**New Rectory, Acre Ditch, Sibford Gower,  
Banbury, OX15 5RW**

**22/00332/F**

**Recommendation:** Refuse

**Proposal:** Erection of a double garage to the front of the dwelling to allow for overnight parking spaces

# Location Plan Planning

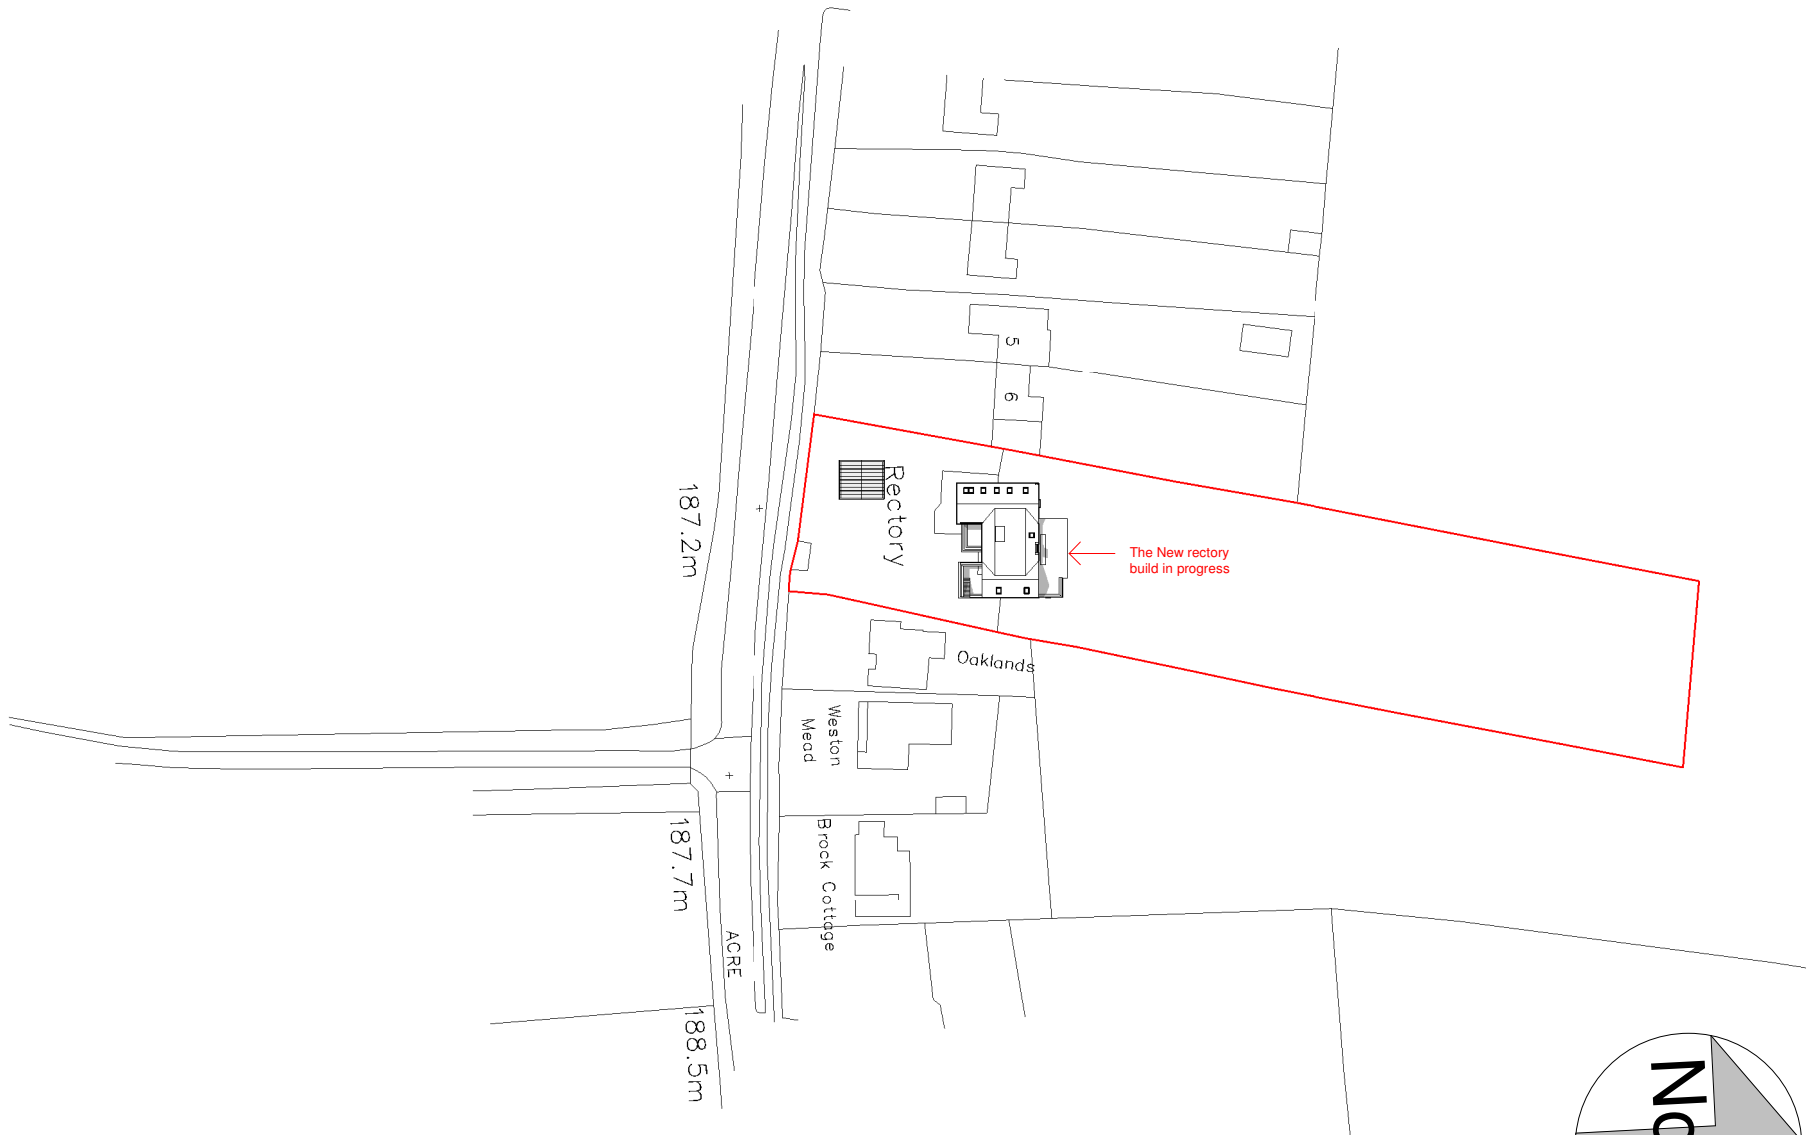
It is noted that there are no other significant built features within the front garden of properties within this area of the village, and as such the proposed scale and location of the garage is considered not to be in keeping with the character of the area, nor would it preserve or contribute positively to the setting of the surrounding conservation area.

It is considered that, by reason of its scale and siting, the proposal would result in a visually incongruous form of development that would adversely affect the character and appearance of the area and would result in harm to the significance of heritage asset through the change that would occur to its setting.
